5th September 2019

- A. Highways England A303 Amesbury to Berwick Down - Consultation on Proposed Non-Material Changes to the Development Consent Order Application

NMC-01 – Existing A303 lay-by west of Winterbourne Stoke to be de-trunked.

Drawing Title
**DE-TRUNKING PLANS
REGULATION 5(2)(o)
SHEET 1 OF 3**

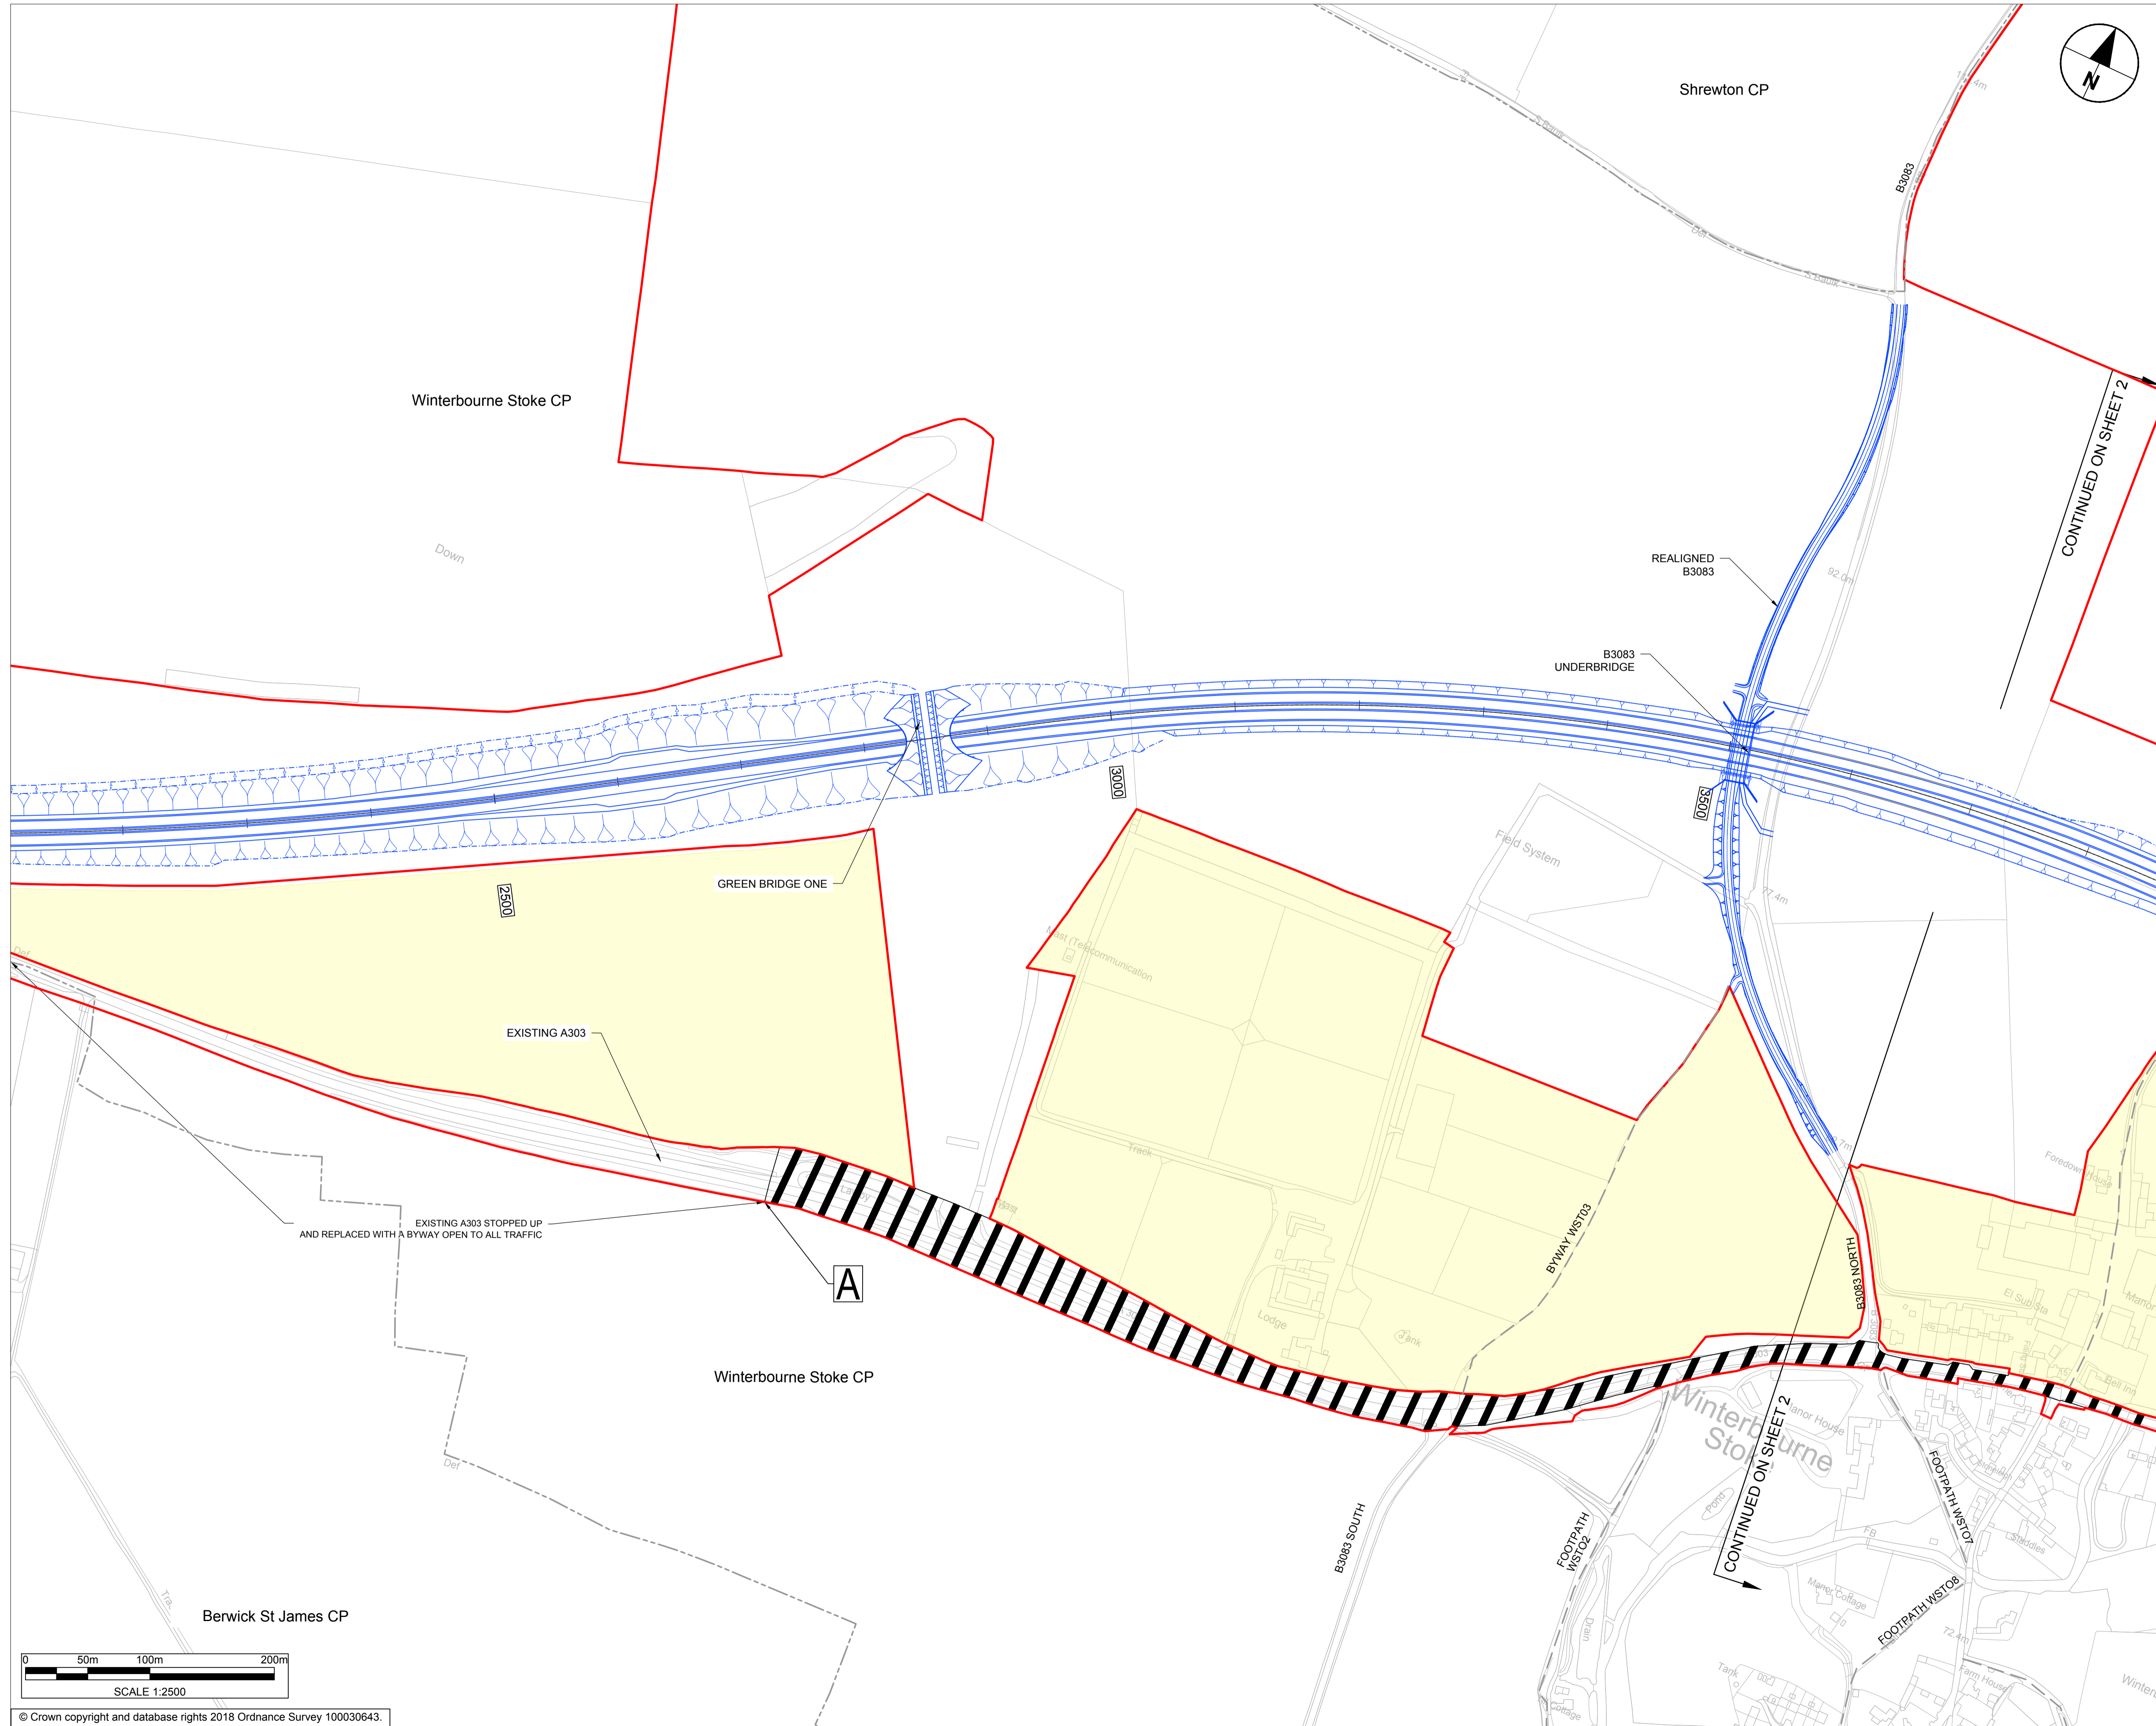
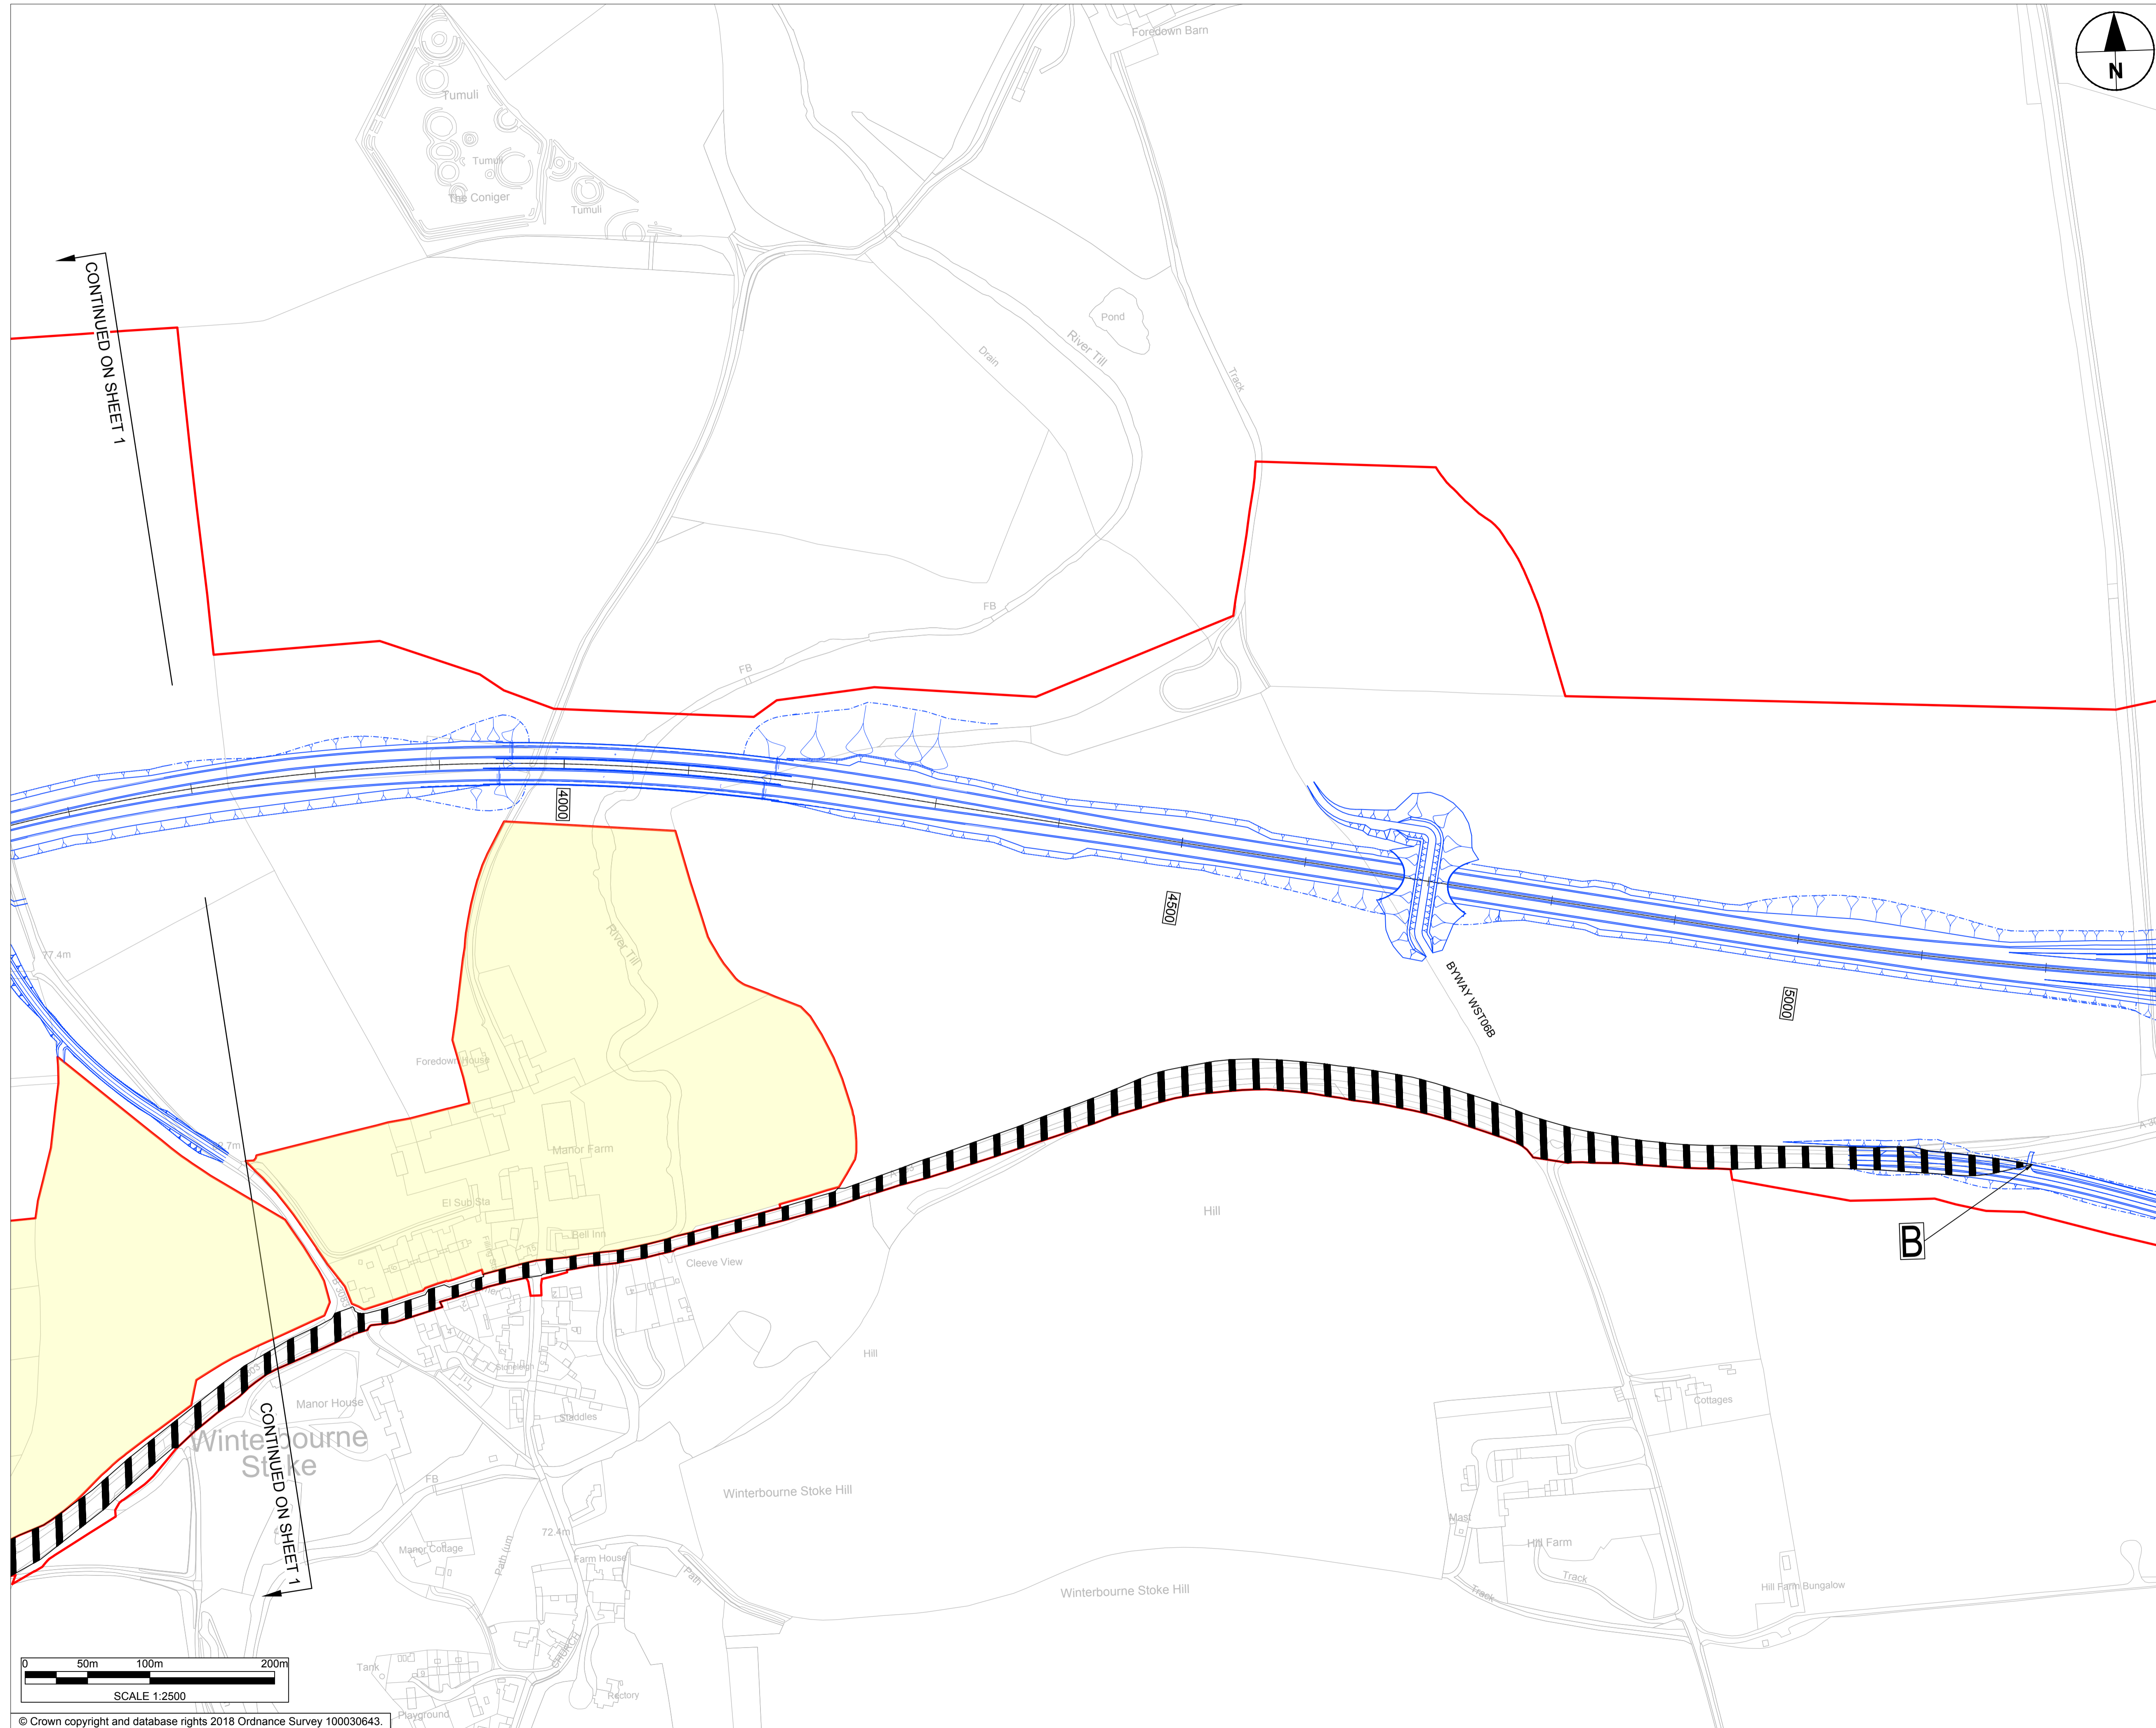
The proposed re-categorisation of the lay-by is welcomed in that it will be “....transformed into a sloping grassed verge that will no longer be accessible to vehicles”. Clarification is however requested on the following points:

- It would aid transparency if the nature of the “transformation” is detailed precisely. For example, is this transformation the complete filling-in of the lay-by or simply the recategorization of the land area. This is important as the reason for this area being brought under scrutiny is in order to prevent it from becoming a focus point for unlawful and antisocial activity. Reassurance is required that the detail behind the “transformation” prevents such activity occurring.

- Clarification is requested as to how this area will “no longer be accessible to vehicles”. Prevention of access can be achieved in a number of ways ranging from the erection of signage to the building of fencing and walls. Clarification is requested as to how vehicles will be prevented from obtaining access to this area.

- It is stated that the lay-by will be handed over to the responsibility of Wiltshire Council. Clarification is requested as to the point in time when this hand over will take place. i.e. Will the transformation be resourced within the Highways England budget for the road scheme or will the responsibility for funding and completion of the works be the responsibility of Wiltshire Council? It is suggested that all these works should be completed by Highways England.

- As stated previously, it is believed that a far more cost-effective method (both short term and long term) of managing this area would simply be to return it to agricultural land and return it to the ownership of the original landowner.

The proposed declassification of the existing A303 from its current road status to an unclassified road does very little to allay the concerns of the undersigned as to future usage of the de-trunked A303. Previous correspondence have listed, at length, the impact of leaving this road freely accessible to all road users. In effect, if the plans are to remain unchanged, this length of road will become the focus of all the antisocial and unlawful activity that currently exists on the roads and byways around Stonehenge that this road scheme is being used to prevent. All this current proposal achieves is to push that activity away from Stonehenge to impact on neighbouring landowners and specifically in the area of this de-trunked section of the A303. It is not disputed that access is required to be maintained along the existing A303 for the purposes of the maintenance of national infrastructure as well as for agricultural access. No other access is required along the de-trunked A303 and therefore this element of road should be gated from the point immediately west of the current access to Scotland Lodge Farm.
